Application for a non-material amendment following a grant of planning permission.

<input type="text" value="Erection of single storey rear extension and internal alterations"/>	
Reference number:	<input type="text" value="06/2016/0995/FULL & 6/2016/0347/LB"/>
Date of decision	<input type="text" value="05/07/2017"/>

Omission of 5no. rooflights from south-facing roofslope.

ROOF PLAN – WITHOUT ROOFLIGHTS (SCALE 1:50)

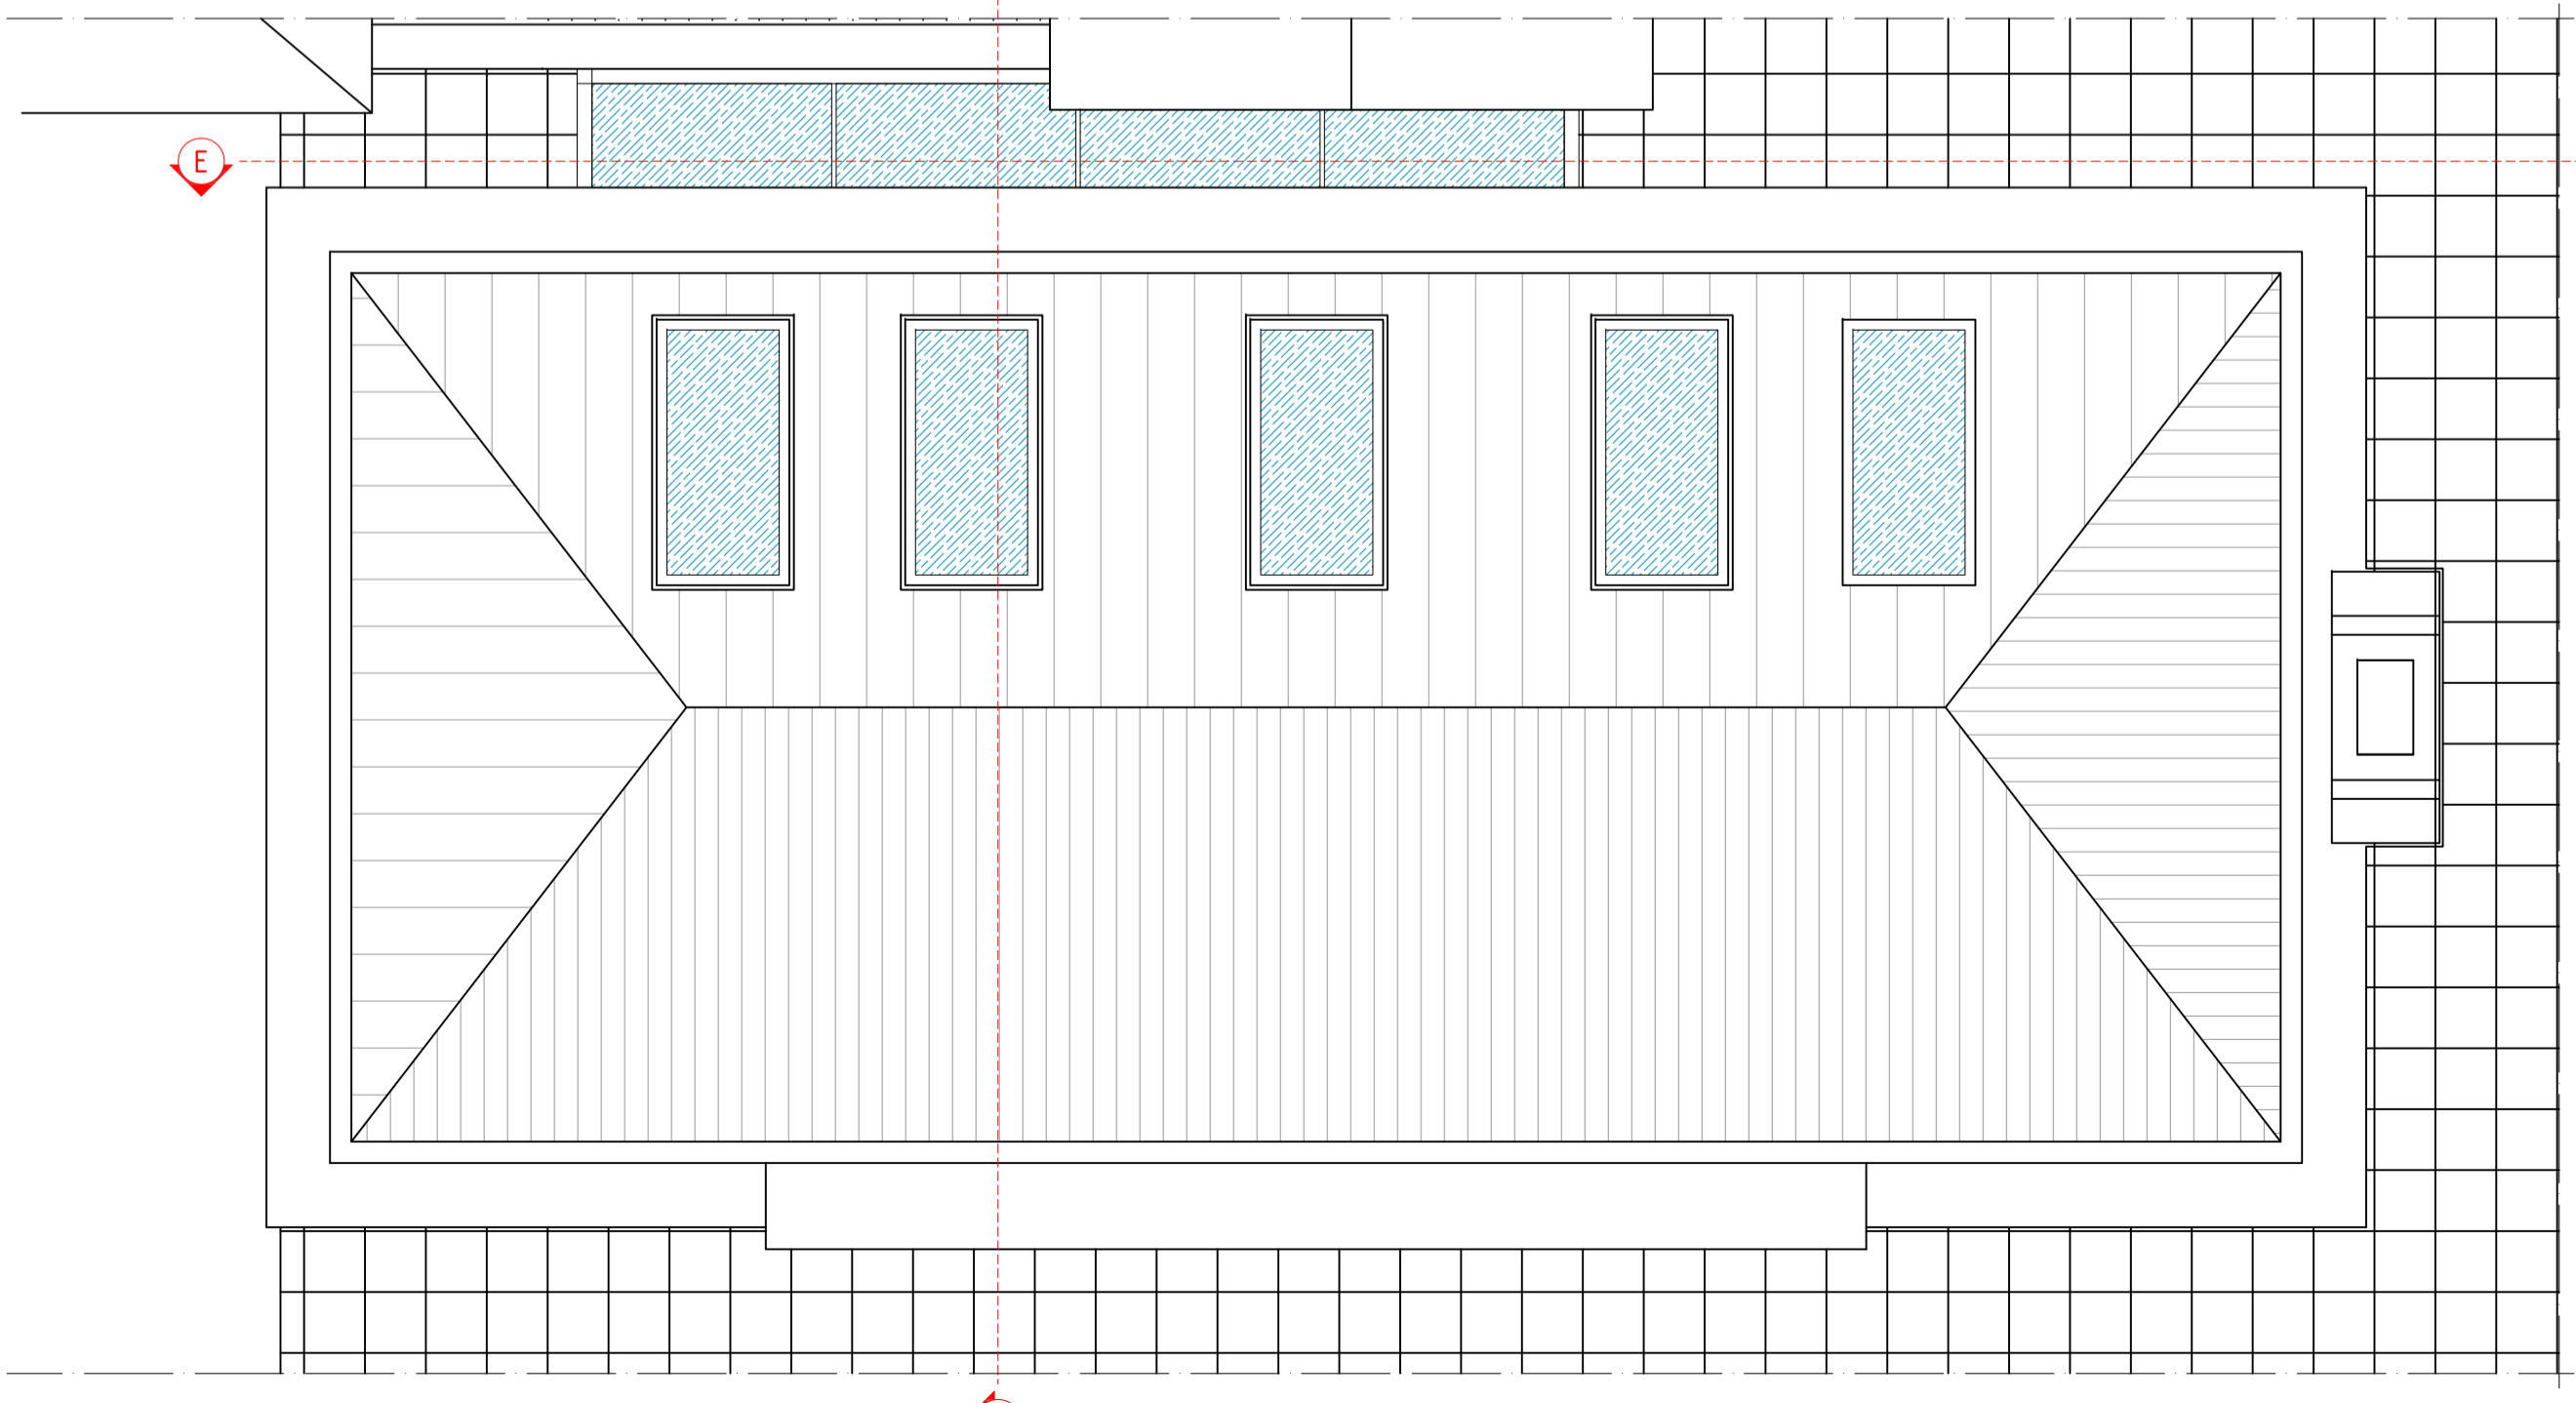
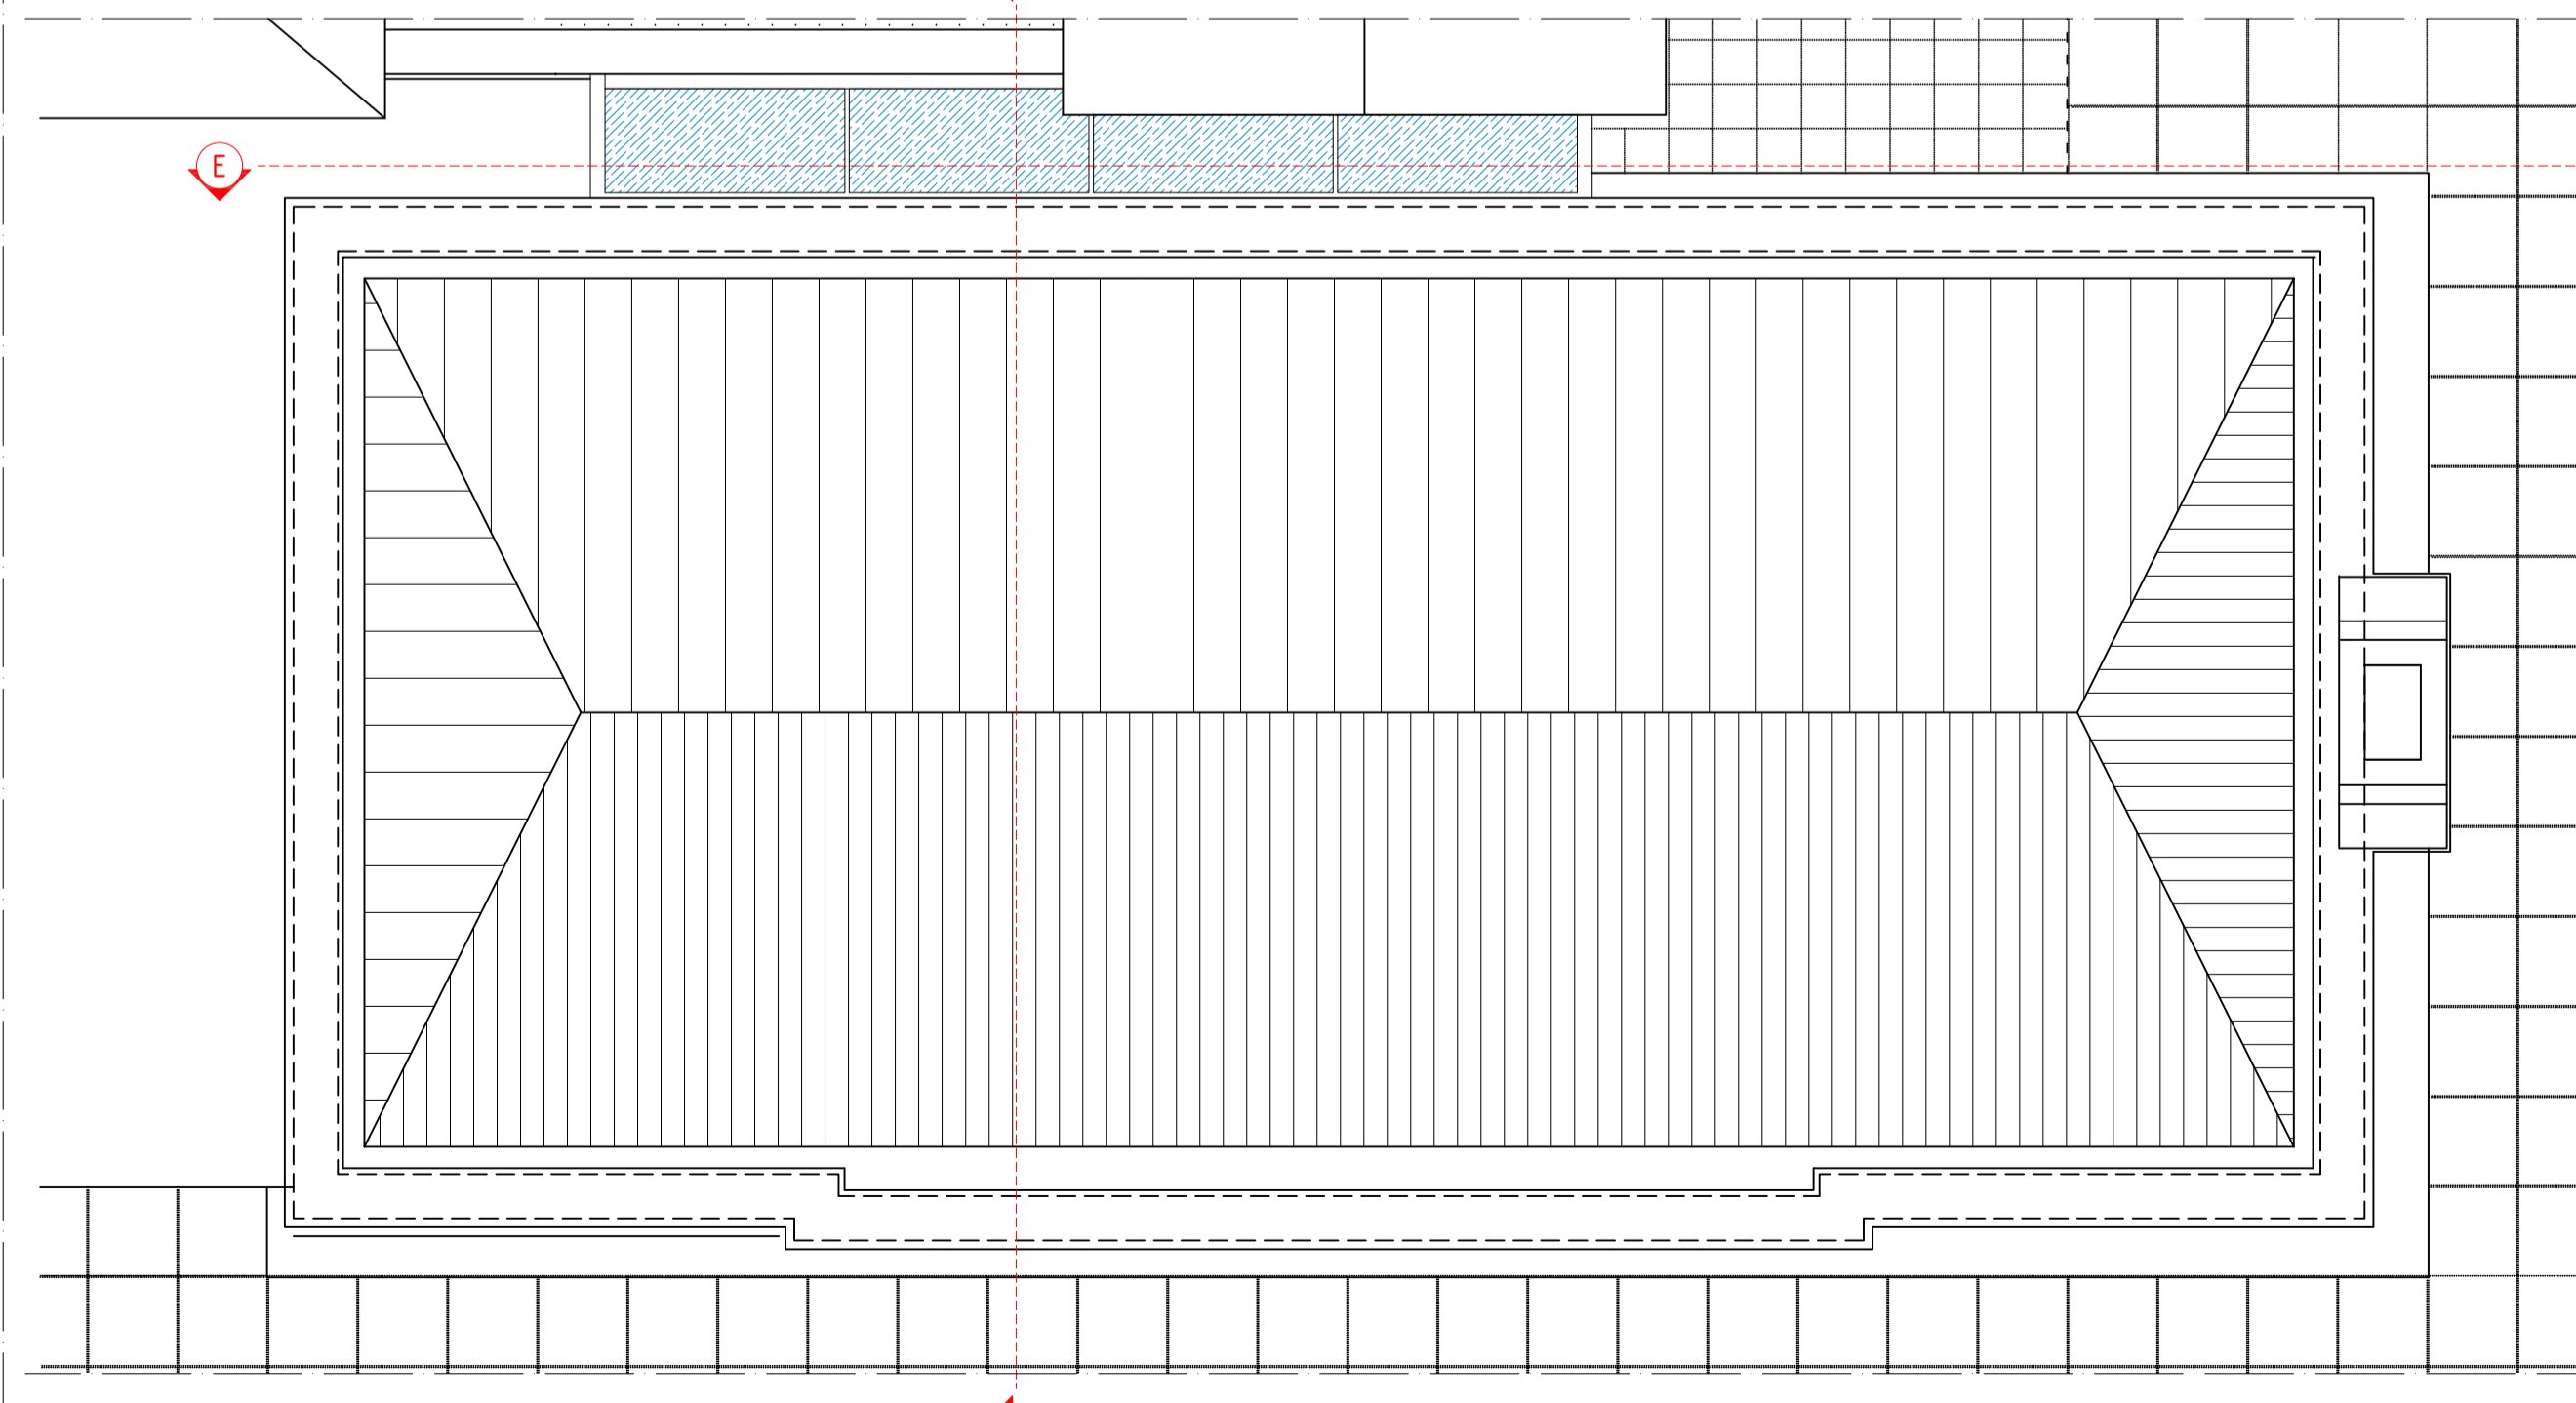
Applicant wishes to omit the rooflights because they will not work well with the intended final internal fit out. For full details see included covering letter.
